COCKLE BAY PARK REDEVELOPMENT

Appendix H Biodiversity Development Assessment Report Waiver Request

15 September 2021

RE: Biodiversity Assessment – Cockle Bay Park Redevelopment

Figure 3: Cockle Bay Park Site Plan (Henning Larsen & Scott Carver Architects 2020)

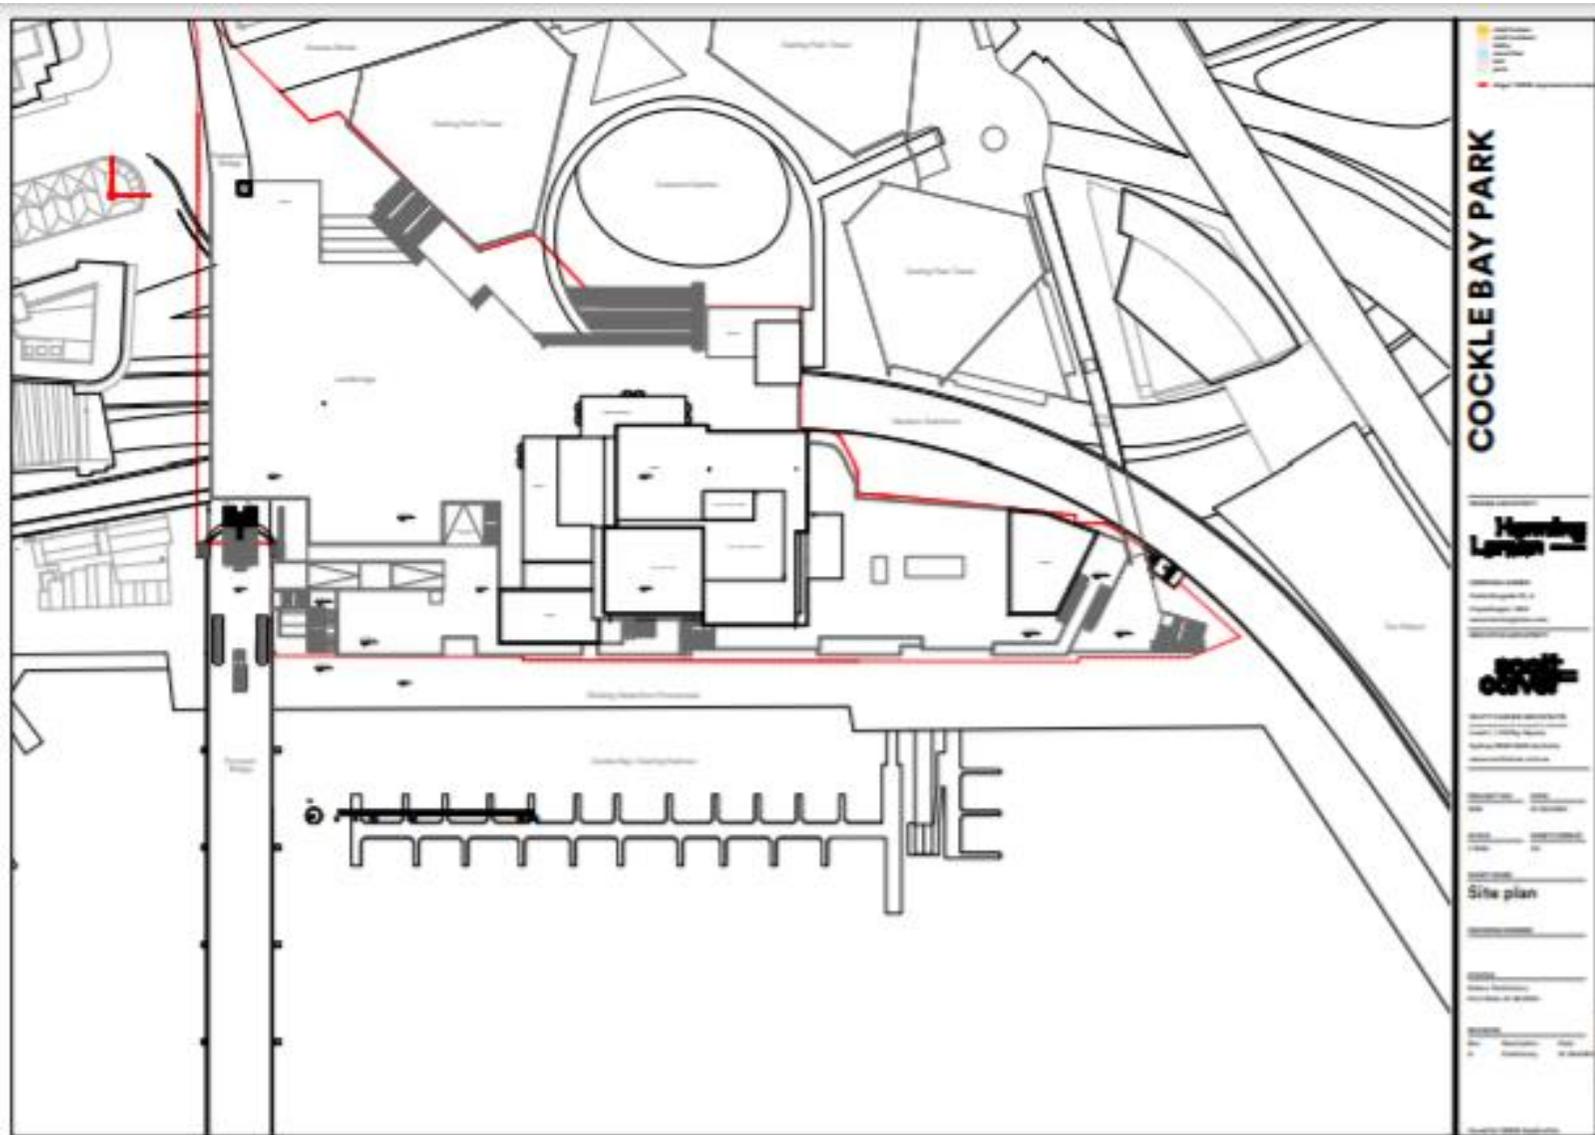
this site plan is very old.
Remove

Figure 4: Tree Locations from the Arboricultural Impact Assessment (ELA 2021)

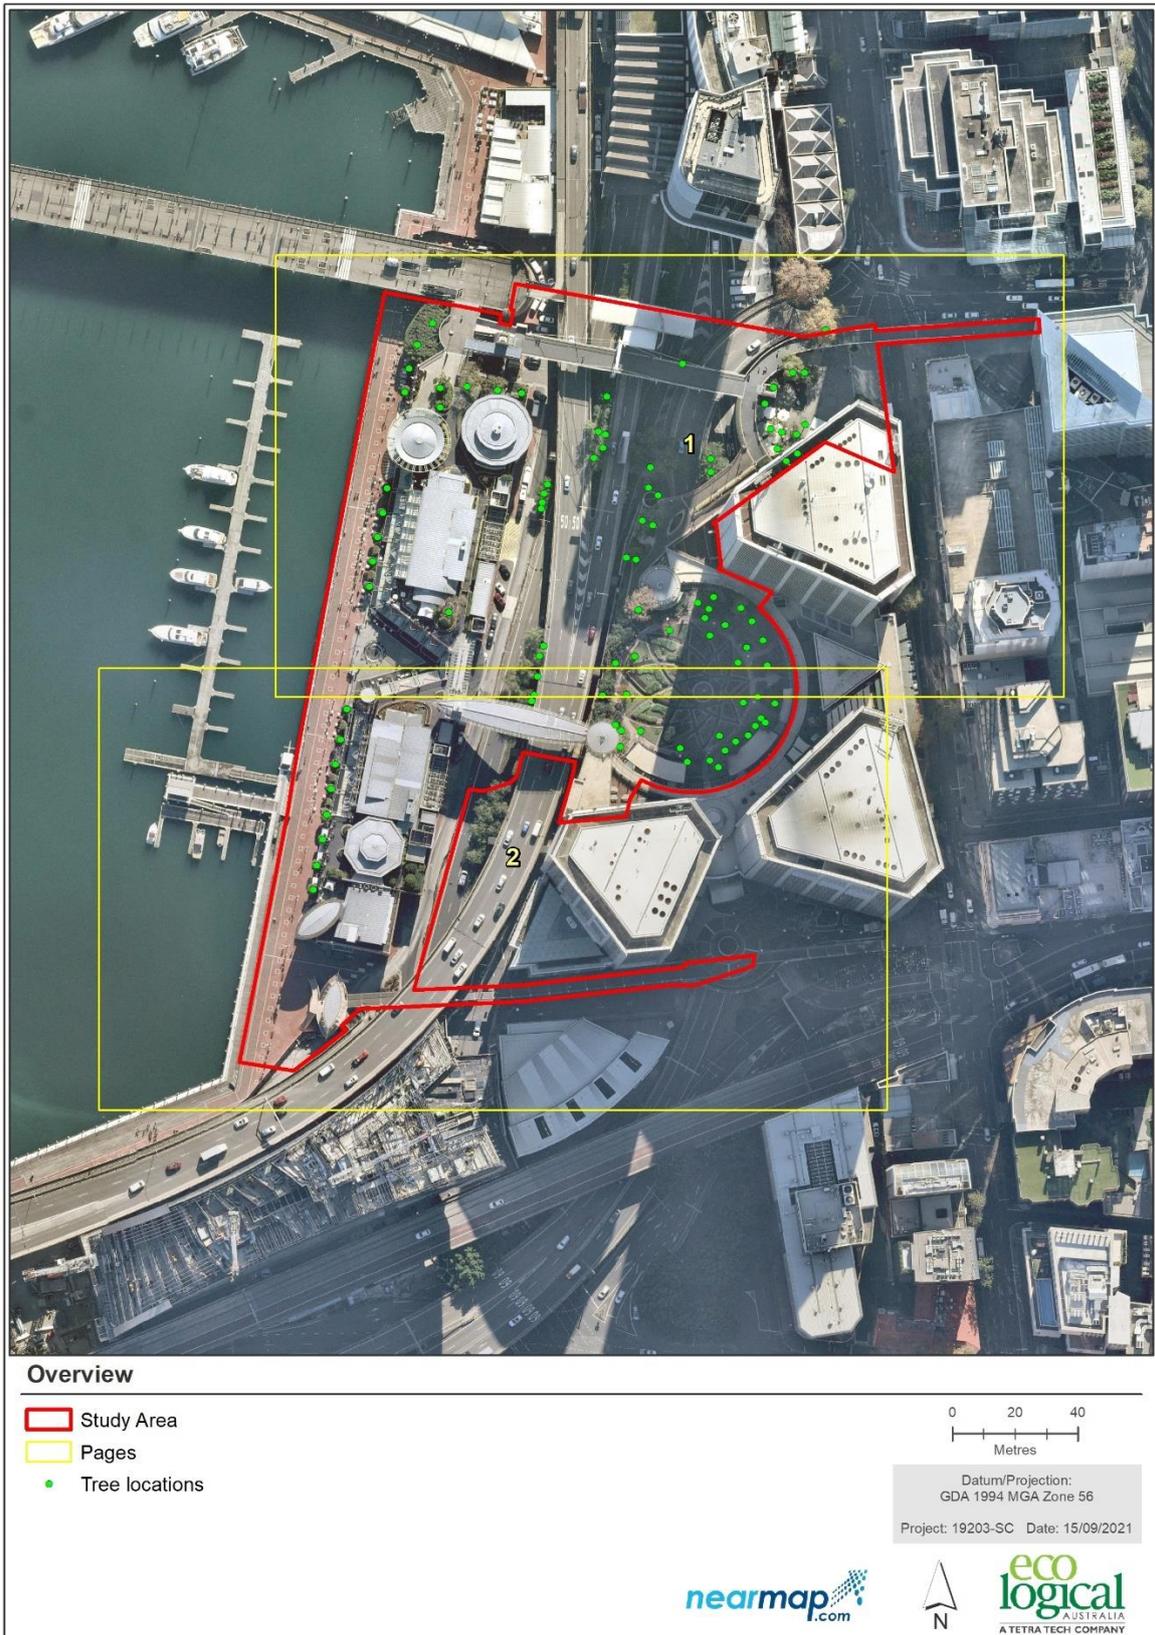
refer to previous EU markup : need to be clear what trees are already approved to be removed and what trees are now required to be removed as part of the Stage 2 DA
